RE: Alternative Landscape Plan – PR-2018-001670 / SI-2019-00181

Upon review of your request letter and the corresponding alternative landscape plan, I have determined that this alternative landscape plan for the indoor storage at 2217 4th Street NW meets the criteria of Section 14-16-5-6(C)(16), and therefore is approved per the following findings:

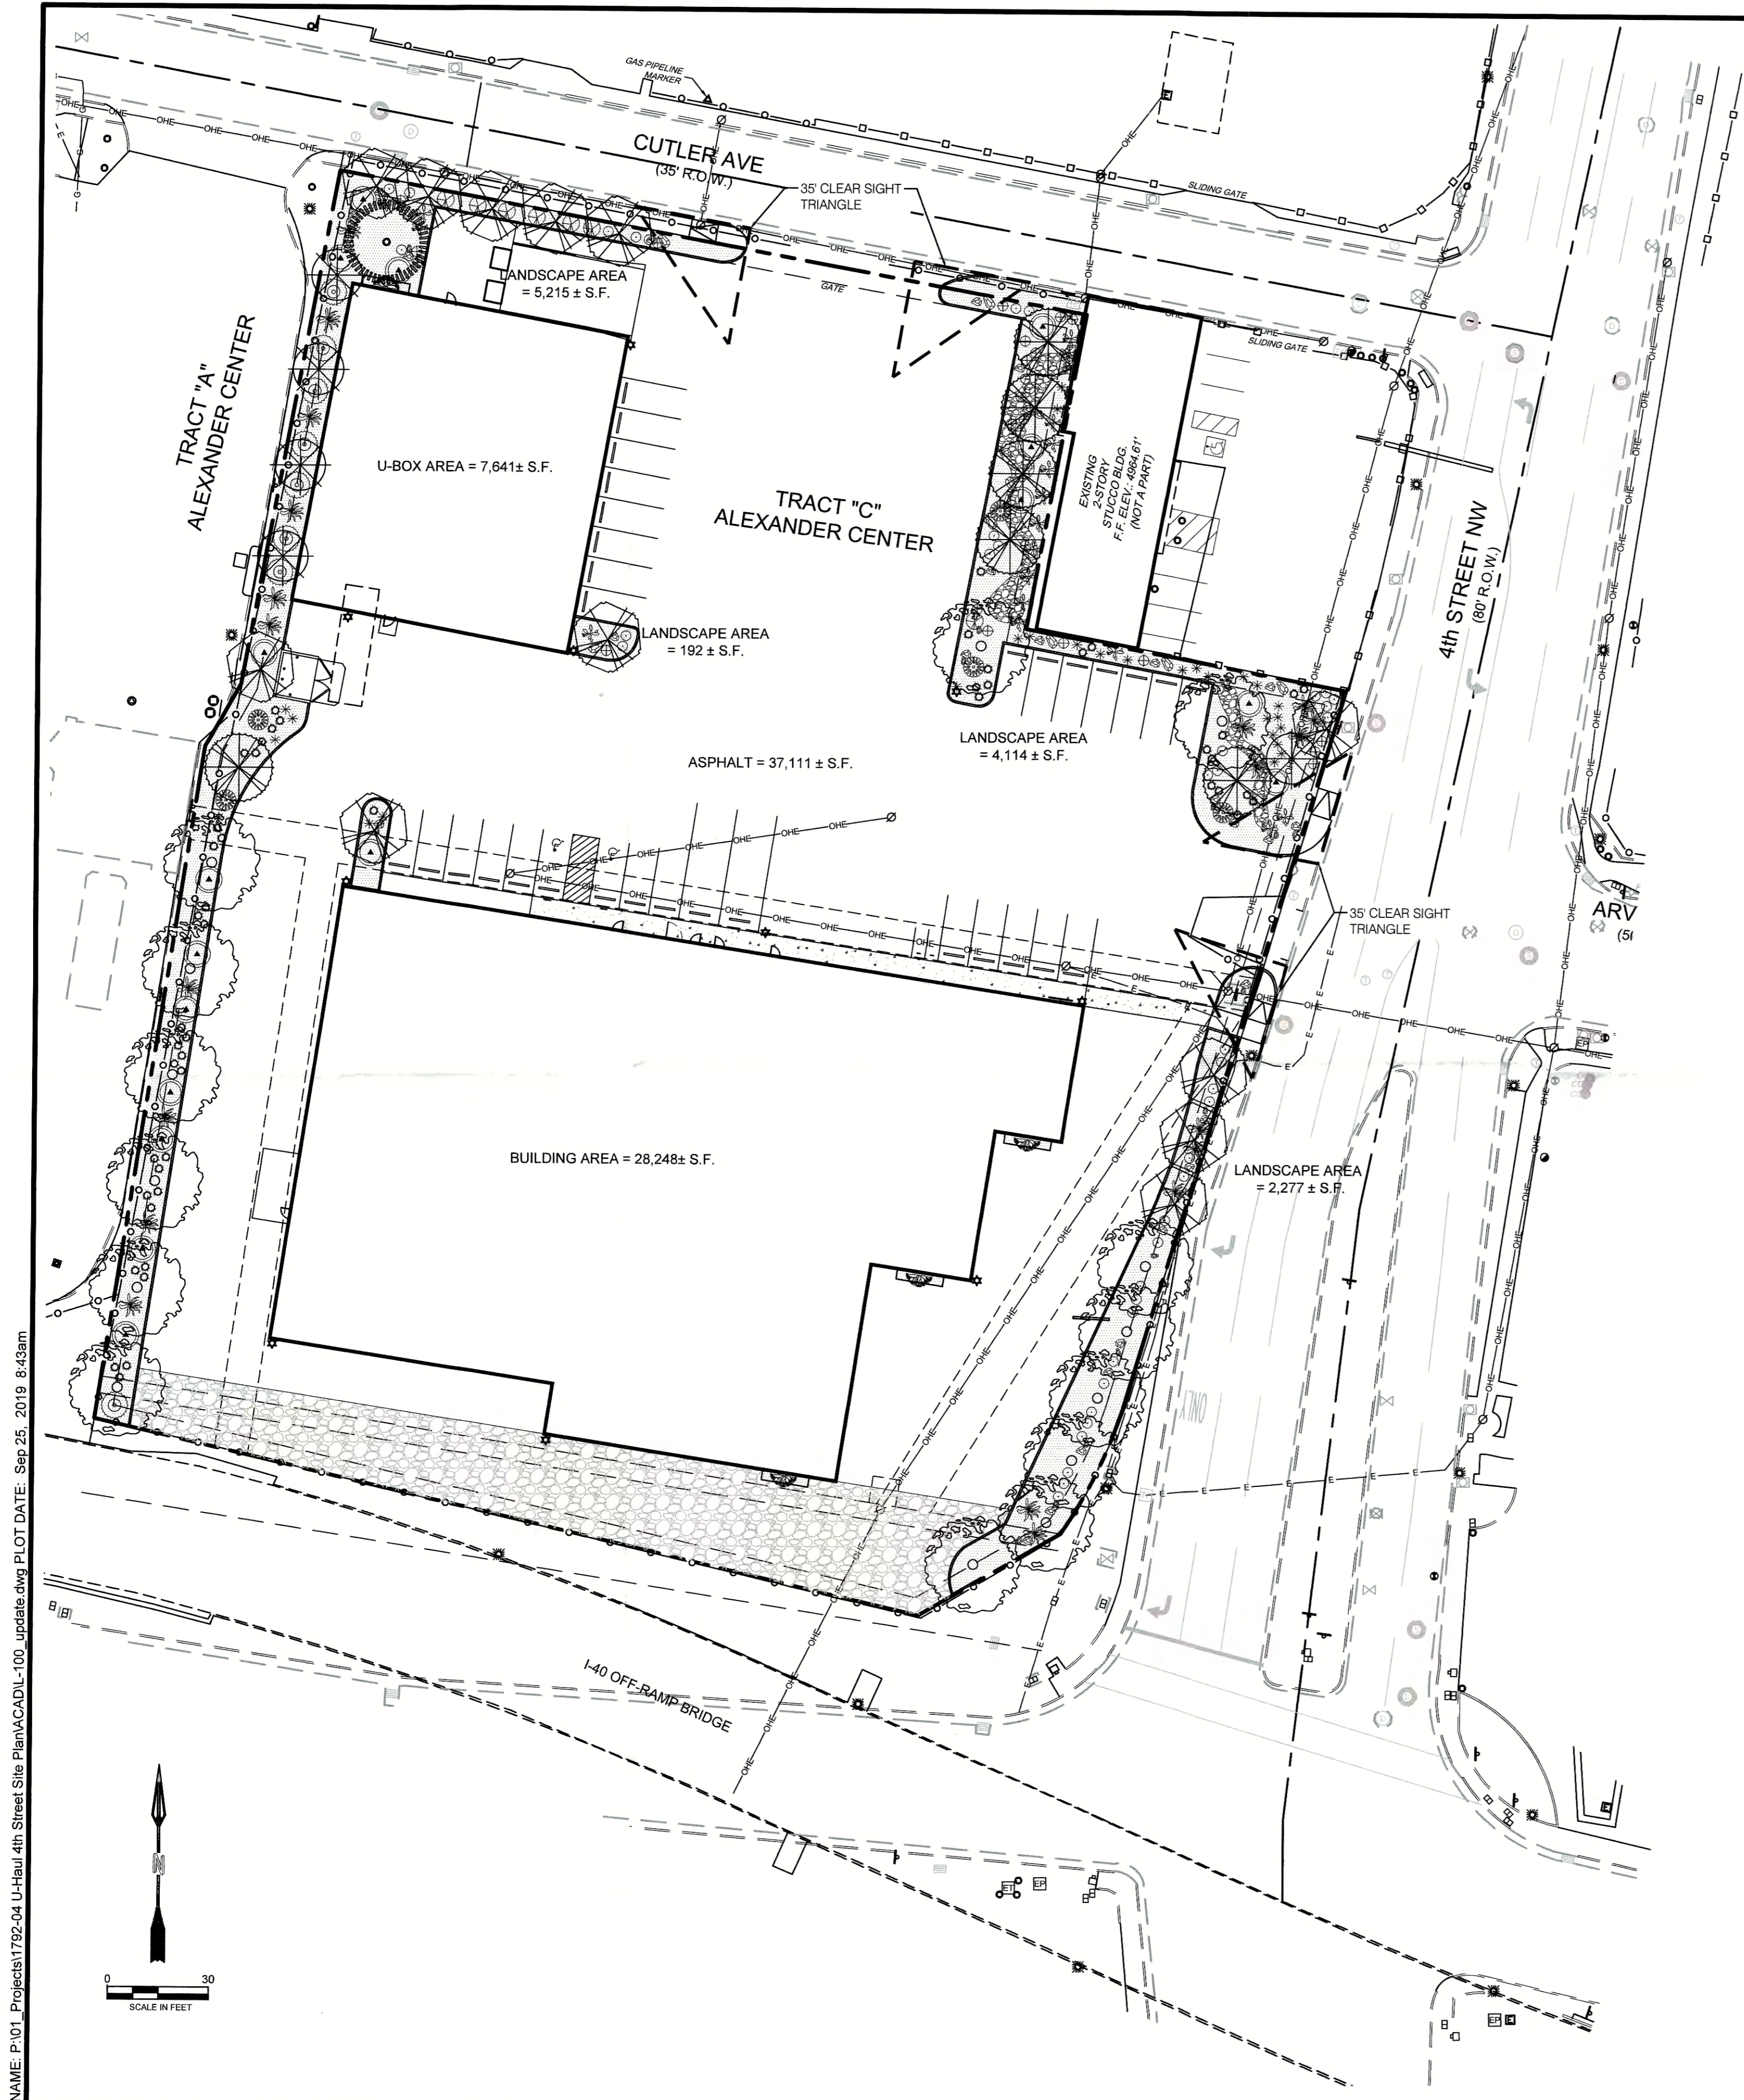
1. The applicant has submitted a Site Plan – DRB for a new indoor storage and office at 2217 4th Street NW.
2. The proposed landscape plan meets all applicable Integrated Development Ordinance (IDO) development standards for landscape, except 14-16-5-6(C)(4)(h): “Shade trees planted approximately 25 feet on-center are required along all required pedestrian walkways.”

3. The submitted alternative landscape plan has located the required number of walkway shade trees in other landscape areas on the site.
4. The architectural canopy element on the building’s north elevation will hang over the pedestrian walkway and provide shade and shelter for pedestrians using the indoor storage facility.

5. The IDO Alternative Landscape Plan criteria of Section 14-16-5-6(C)(16) are met as follows:
 - a. The alternative landscape plan is consistent with purpose of Section 14-16-5-6 because: the required number of trees will be provided; the alternative approach provides a quality visual component and other public benefits including the use of native and low-water use species, improved air quality, and providing shade to mitigate heat-island effects with grouped trees along the north side of the building.

- b. The proposed landscaping will not include vegetation that is prohibited or invasive or listed as noxious weeds.
 - c. There will be no reduction of tree planting requirements. The required numbers of trees are distributed where required and in other locations that will benefit the site.

- d. The alternative landscape plan does not affect perimeter buffer or landscape areas.
 - e. The alternative landscape plan provides an equal visual appearance of the property when viewed from both 4th Street NW and Cutler Avenue NW.
 - f. The design will provide equal levels of carbon dioxide absorption and heat island reductions.
6. Development of this infill site with the provision of the required number trees is consistent with the ABC Comp Plan Vision for desired growth in or near existing and designated Corridors (Main Street).
 7. The applicant addressed concerns and suggestions from the Near North Valley NA with notable responsiveness and alacrity.

The applicant's and designer's alternative landscape plan is consistent with the purpose of the IDO's landscape regulations, further enhances the city's built environment, and is appropriate for this infill project in this location.
